WATERLOO METRO QUARTER OVER STATION DEVELOPMENT

Basement SSD-10438 -
Response to Submissions

Prepared for
WL DEVELOPER PTY LTD
15 February 2021

Proposed Scenario - 1% AEP

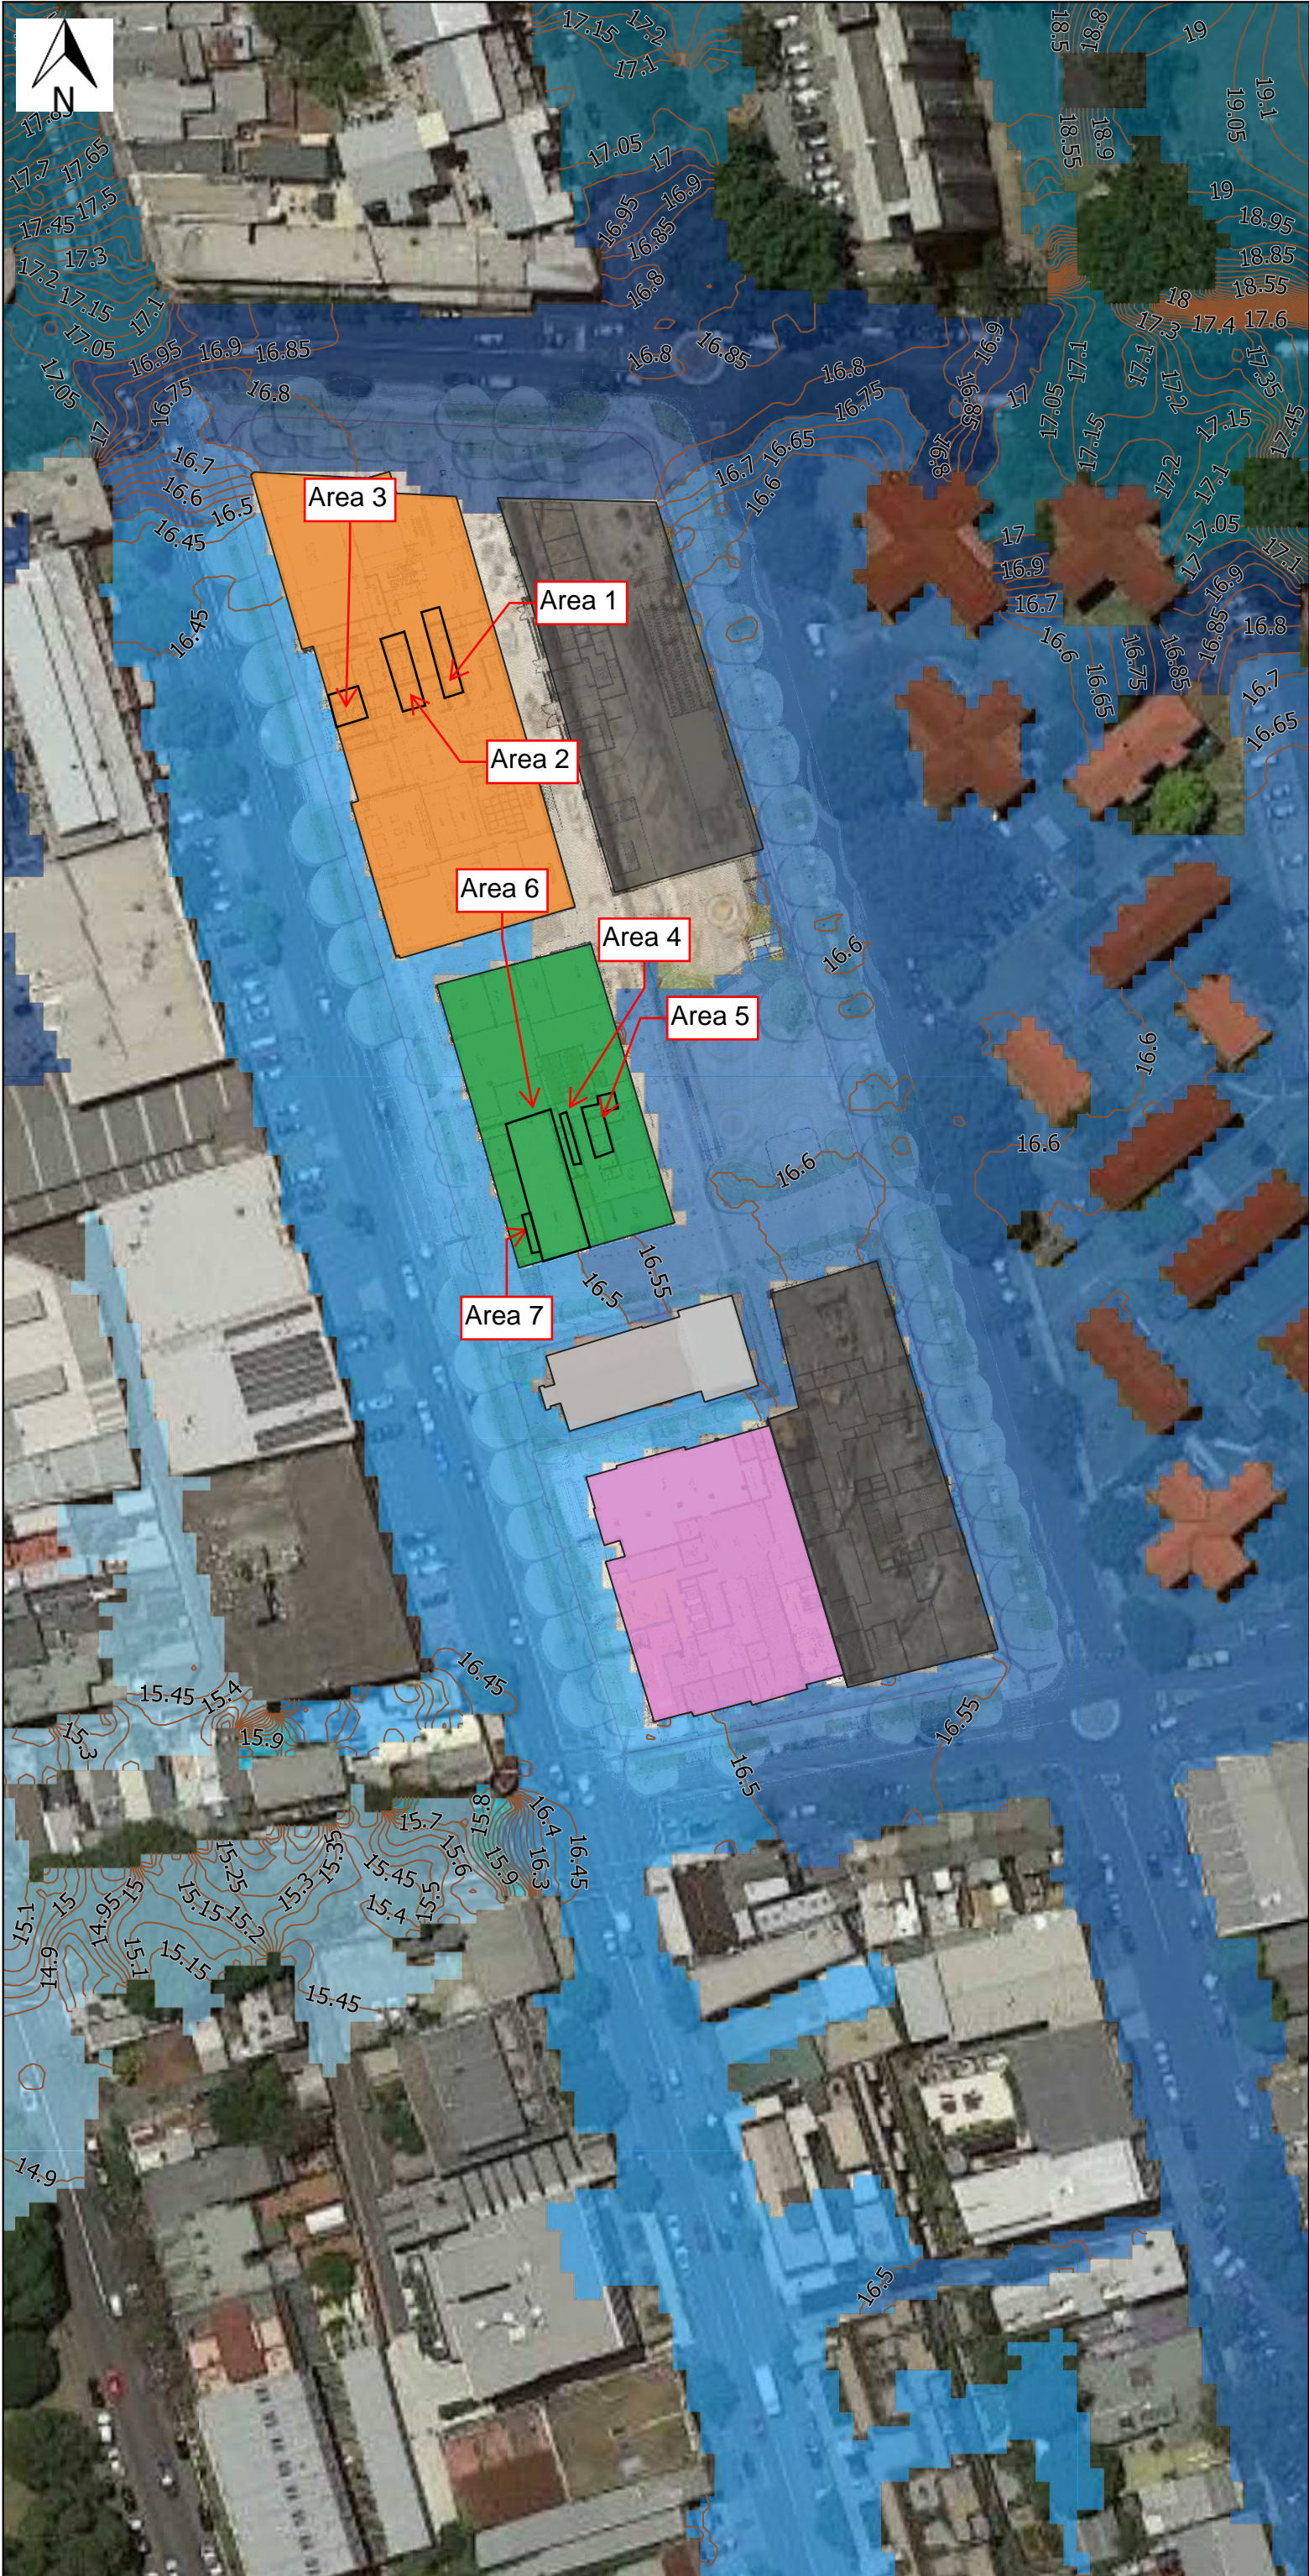
Comment	Response
	<p>PMF flood events as requested within this submission. The technical response also outlines the finished floor levels of the ingress points to the basement.</p>
<p><u><i>Flood impacts of the proposed development</i></u></p> <p>The individual buildings of the over station development are not expected to cause any flood impacts; however, the ancillary road works are predicted to cause unacceptable impacts.</p> <p>An acceptable tolerance for flood level increase would be 10mm. Appears road works were not included in concept stage modelling in Concept Water Quality, Flooding and Stormwater Report of 2018.</p> <p>Require mitigation measures to ameliorate the flood impacts to be finalised and submitted for review by EES before a recommendation for approval can be made.</p>	<p>As agreed within this submission, we note the construction of the OSD buildings (and basement) are not expected to cause any flood impacts.</p> <p>Concern is raised in this submission regarding the acceptable tolerance for flood level increases within the surrounding road network and neighbouring properties resulting from road works.</p> <p>The scope of works proposed within this Basement SSD (SSD-10438) does not impact the extent of localised flooding surrounding the Waterloo Metro Quarter site.</p>

APPENDIX B – BASEMENT FINISH FLOOR LEVELS

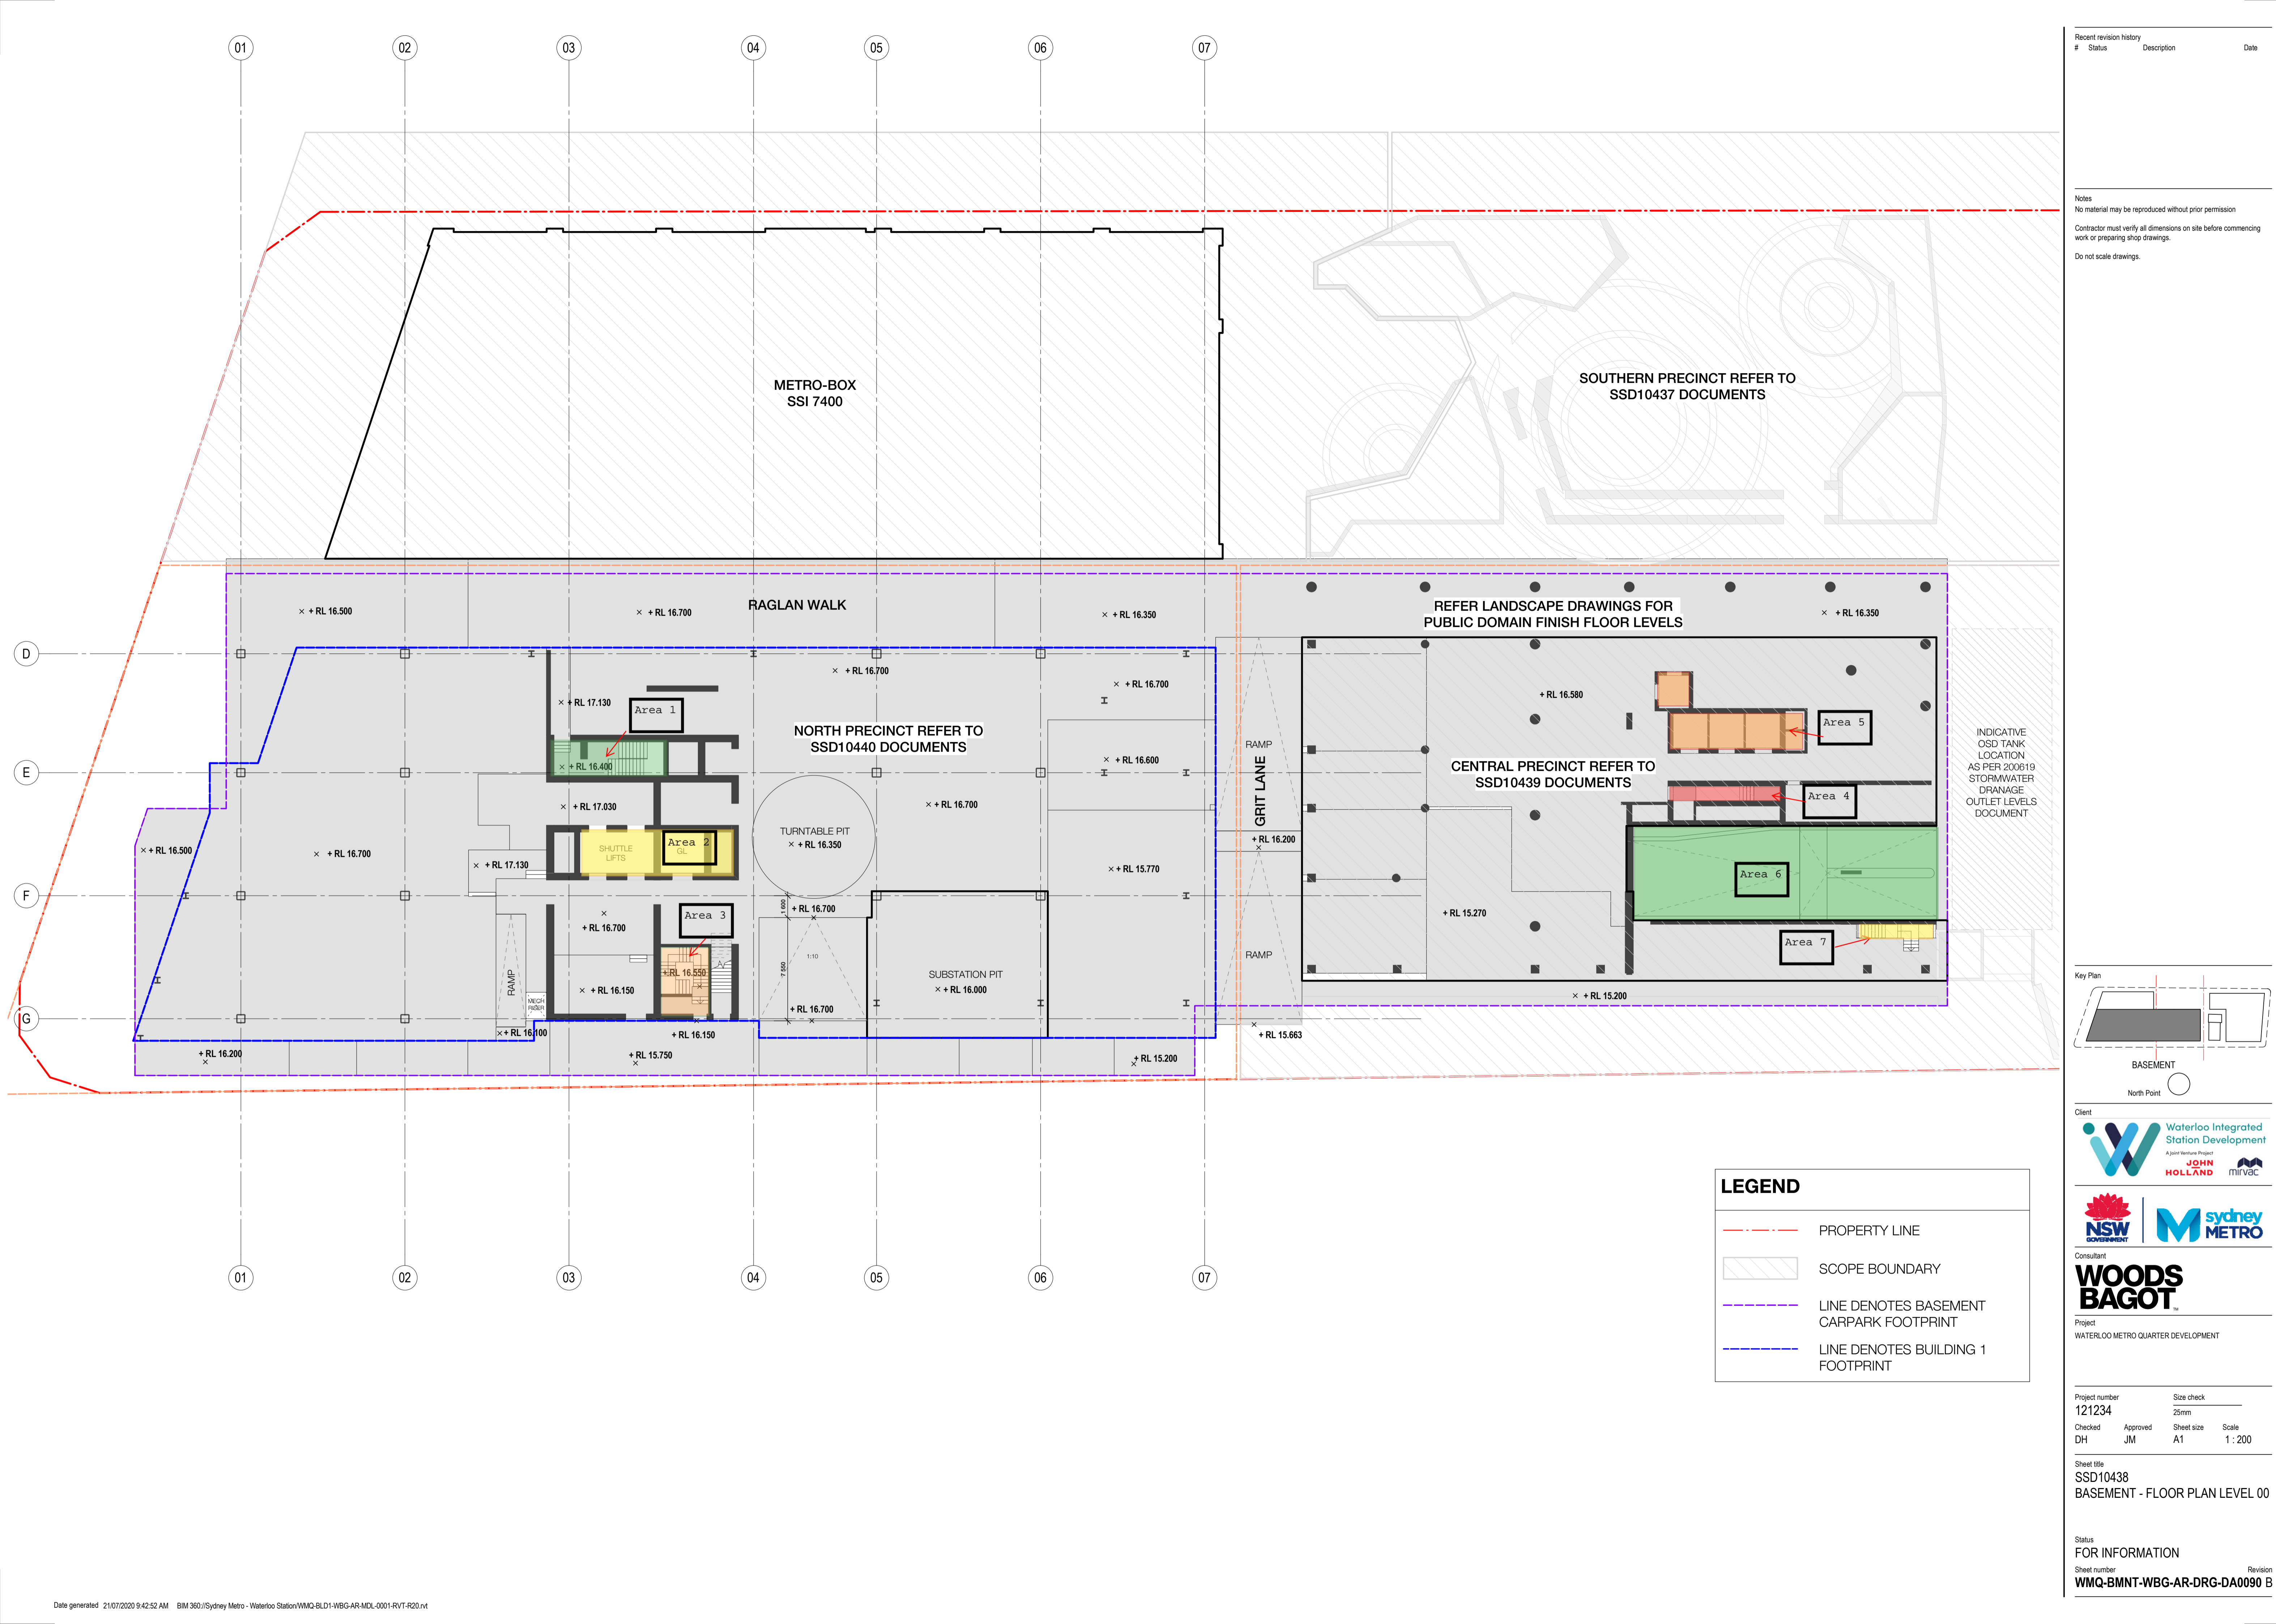
<p><u><i>Flood risk for the development – Flood Planning Levels</i></u></p> <p>Generally, floor levels are above the 1% AEP flood level and generally above the PMF level. Where required at entries to basements, 500 mm freeboard to the 1% AEP flood level appears to have been provided. However, the report has not adequately documented all the proposed finished floor levels (FFLs) to enable their comparison to the proposed FPLs.</p> <p>As a minimum, the FFLs need to be provided in Table 4 alongside the FPLs.</p>	<p>The design of the basement has responded to the flood planning levels required for the site as outlined in Appendix H.</p> <p>All points of ingress to the basement are at or above the 1% AEP + 500mm freeboard and PMF flood levels (whichever is higher).</p>
<p><u><i>Flood risk for the development – Residual Risk and Emergency Management</i></u></p> <p>Need to demonstrate “Safe refuge can be provided within the proposed development.” Issues regarding residual risk that need to be addressed and require amendments to the design.</p> <p>A proper assessment of the flood behaviour as it relates to emergency management is required, together with the development of a strategy for flood emergency management.</p> <p>Shorter and longer durations should be considered for emergency planning, not only the duration that</p>	<p>As outlined above, the basement is protected from potential flooding impacts given all points of ingress to the basement area at or above the PMF and 1% AEP + 500mm freeboard flood levels (whichever is higher).</p> <p>No evacuation is necessary from the basement as sufficient flood protection is provided within the basement. In a flood emergency occupant of the basement can remain safe in the basement until the flood emergency is finished.</p> <p>The site area is located at the top of the catchment and only events with short duration and high</p>
